Comments And observations to Highways England response to Relevant Representation questions  
for ease of reference I have used the references as detailed in H E detailed response.

### **A1 in Northumberland Morpeth to Ellingham.**

**Statutory Consultation 16<sup>th</sup> April 2020 to 14<sup>th</sup> May 2020.**

Figure 1 – DCO Application proposed PMA Route

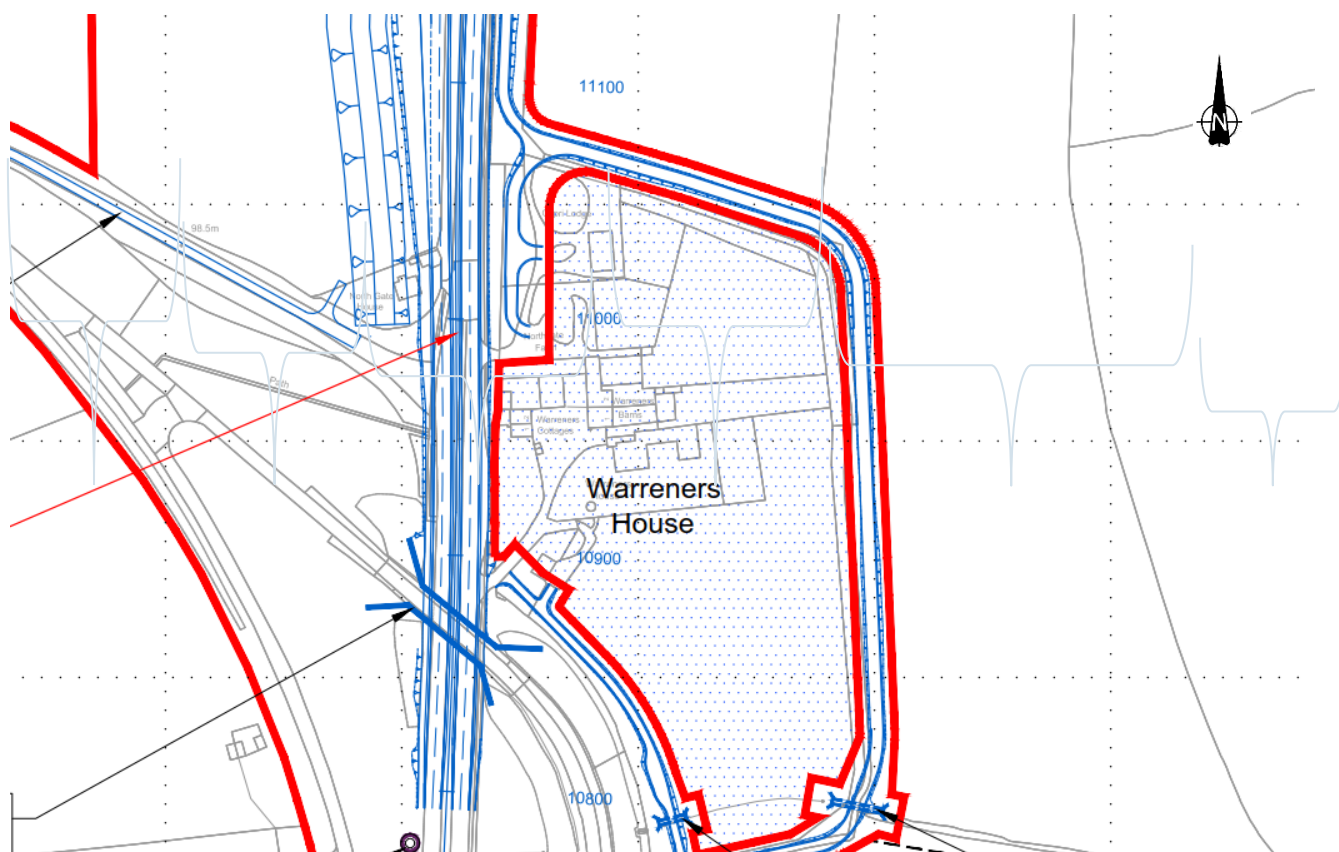
**Point 1** refers to the grounds of the Old Northgate Site which implies that the hospital is no longer in existence or affected by this proposal. This is incorrect as these proposals impact not only on West View in particular but also on the access to the hospital (which is still operational and currently expanding) this road is also access for the residents of the current housing development and the proposed future development.

The applicant has stated that they are proposing to undertake these works as part of the application and have further stated they will provide additional parking bays. That been the case then it would appear that the application is to upgrade the existing road to adoptable standard provide a footpath to the western side of the road and install a couple of parking bays, therefore other than increasing the width of the overall carriageway by the inclusion of the footpath the existing road is not intended to be increased in width. I have been unable to find anything within the documentation to indicate an increase to a two carriageway road on West View to accommodate the increase in traffic volume and the size of the Vehicle and type of vehicle using the road. We had been told previously that the road would be widened to two lanes This documentation would suggest it will only be single lane. Please advise what the intention are

I have previously explained in depth to HE representatives during the Statutory Consultation 16<sup>th</sup> April to 14<sup>th</sup> May 2020 (appendix A) my reasons for stating that they have not complied with the CDM regulation in short The CDM regulations state that The designers should avoid the risks they have not done so. I contend they have designed risk into this proposal. Likewise the HSE Risk

assessment documentation describes the hierarchy of control and states the first control as **Elimination** – (redesign the job, or substitute a substance, so a hazard is removed or eliminated.) This has clearly not been done. Had it been executed it would have shown that the by choosing an alternative route as described in (Appendix A) The dangers to the residents in West View During the construction phase and when the road is in use would have been eliminated in this area of the works The Alternative route i have alluded to eliminates the works in West View (Currently a cost bourn by the housing developer not HE) takes away all H E construction works in West View, eliminates additional traffic in particular large farm machinery from West View The hospital main entrance road and away from the increasing number of residents within the complex.

To summarise the applicant has missed an opportunity to eliminate all of the works associated with West View thus eliminating the dangers during construction and when the proposal would be brought into use.

I have previously brought to the attention of the design team a current concern regarding flooding in the area adjacent to no 11 and 12 West View and have supplied photographs to the designers of previous incidents where flooding from the fields North of West View over spills and runs down like a river past the properties on West View. A visual look at the field shows the land falls from the North Southwards and from the East to the West the lowest point been adjacent to no 11&12 West View. The surface water fills up a ditch which is located behind the gas Pumping house and the hedgerow which segregates West View from the fields to the North.

The proposal to open up the area at the point where the pumping station will be removed for the proposed road will then divert the flood water down on to West View.

Acknowledges that there will be a band of trees and hedge row removed but it has to remember that there also will be the removal of the gas pumping station also. Therefore at the point where the road will enter the fields to the North there are currently 3 layers of noise protection at this point namely the gas pumping station the hedgerow and the trees after the hedgerow.

To achieve this entrance, all of these three lines of sound defence would have to be removed at the entrance point for the width of the road and working space either side of the road this will provide a significant gap at a point almost touching the A1 and the slip road from the A.697... This opening has the potential to act as a funnelling effect directing the noise down West View.

The applicant states that the PMA (private means of access) is the reason to relocate the gas house, If that is the case it would therefore probably have to move Eastward as there is little land to the West of the proposed opening, this would therefore move the gas house closer to my property increasing the risk to my property. The gas was installed many years after the properties were constructed it is clear the gas house at that point in time was located as far away from the properties as possible obviously for safety reasons. The relocation of this would also have to be well away from the PMA as there will be risk of damage to the gas house from traffic using the road. This consideration would therefore move the gas house even closer to my property

1 At present bin wagons, large wagons, 7 tonne plus struggle to negotiate this street and most have to reverse up to ensure easy exit from the street without going on the grass at the North of the Street to turn . How will this be dealt with within the design?

6.1 Where will the PMA commence, is it at the edge of the turning circle or will it commence at the line of the hedgerow?

6.2 If it commences at the edge of the turning circle then there will be a stretch of road where the residents of West View will not have ability to ensure it is maintained in good order. Or is it the intention to commence the PMA at the hedgerow? If so will the stretch of road from the edge of the turning circle be of adoptable standard and adopted by the Local Authority? Previous consultations have not answered these questions

6.3 We were once advised the track would be of a compacted hardcore construction with passing places if that is the case no doubt mud from the farming operations will migrate on to the track and within a short period of time contaminate the hardcore Therefore if this PMA commences at the turning circle the migrated mud and the excess water previously noted at **Ref 1.17.2 point 1** of this response Will form a mud mess on West View. If the section of road from the edge of the turning circle is adoptable standard there is still the prospect of this muddy sludge running down West View.
